Your ref: SSD 10457  
File no: MC-20-00003

**SSD 10457- Eastern Creek Retail Outlet - Stage 3**

## Blacktown City Council submission to SSD 10457- Eastern Creek Retail Outlet - Stage 3

Figure 6: Arboricultural impact assessment, west

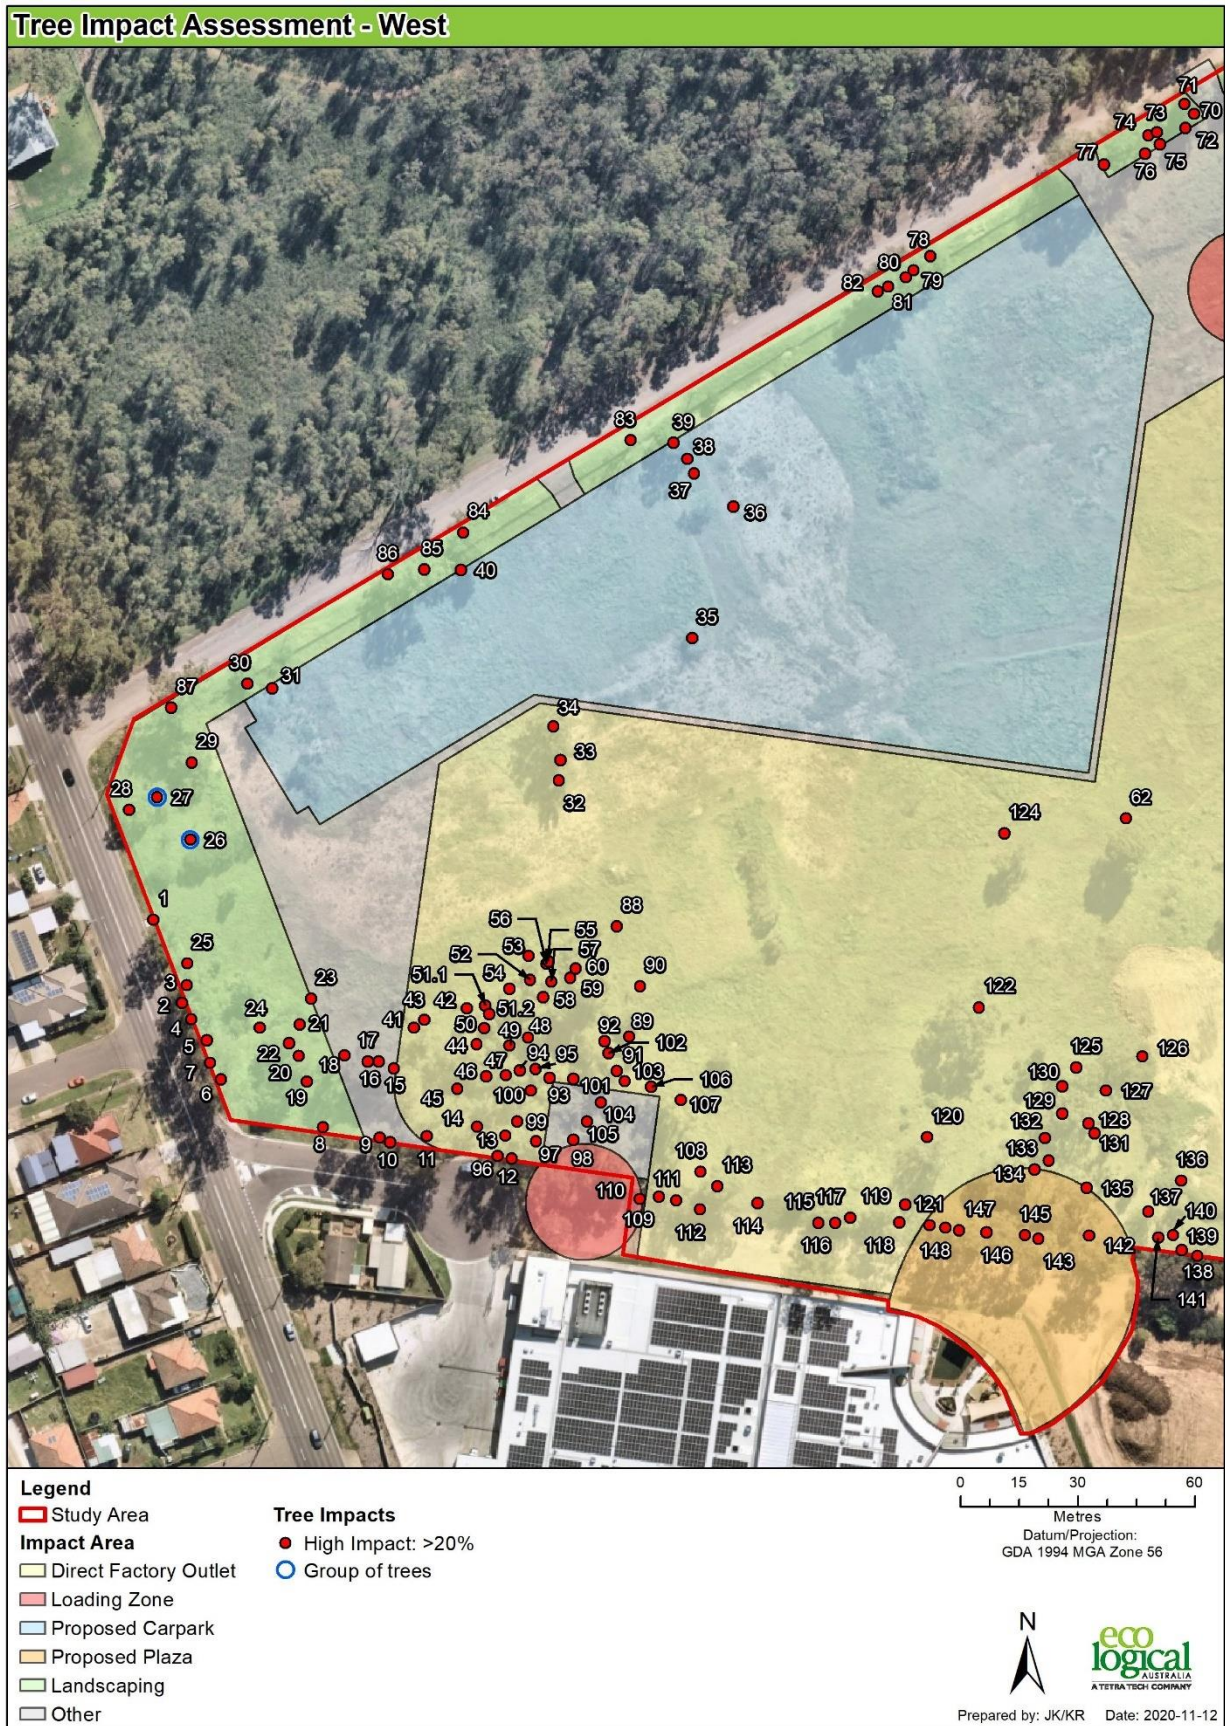
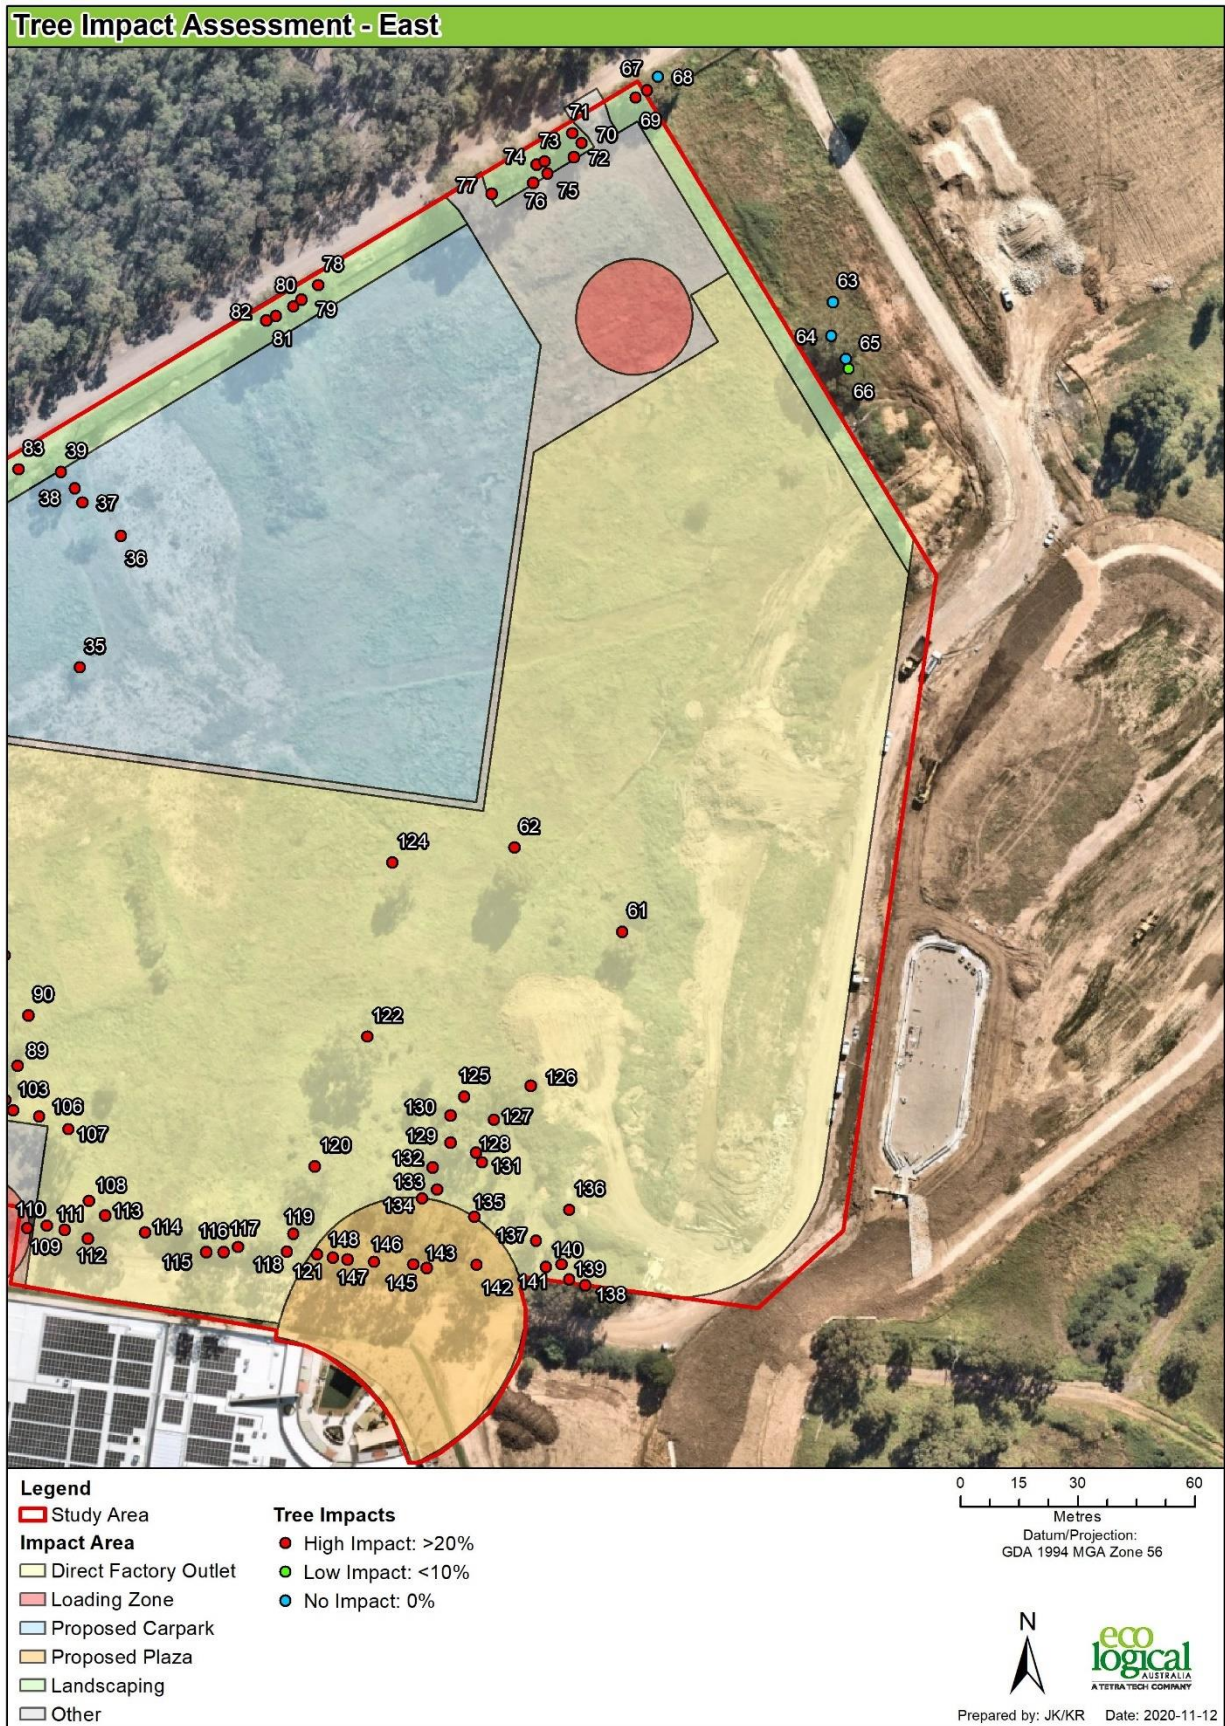
- Our tree management section has reviewed the Arboricultural Impact Assessment (AIA) and has indicated that removing 147 trees is of significant concern. The report does not advise specifically how these trees will be impacted (only affected by the proposed development). The trees within the proposed Factory outlet building and carpark footprints are evident, and there will be 100% impact/encroachment into the Tree Protection and Structural Root Zones. The trees located within the landscaping area indicated on drawing No. SK23.1 are potentially able to be retained despite the AIA indicating High Impact encroachment.

- Trees located within the Landscape areas (10 m and 20 m landscape setback and area 12 indicated in drawing No. SK23.1) which have High and Medium Retention Values, and trees outside of the development area (trees 63-68), are to be retained and protected in line with Australian Standard AS4970 2009 Protection of trees on development sites. A specific Tree Protection Plan is to be submitted to Council for the specific protection of these trees, incorporating advice as indicated in section 4 of the AIA.

- A review of these trees can be submitted should the applicant provide specific details as to why they are required to be removed. Detailed information about the encroachment in the TPZ and SRZ should be presented along with a site-specific landscape plan for the area.
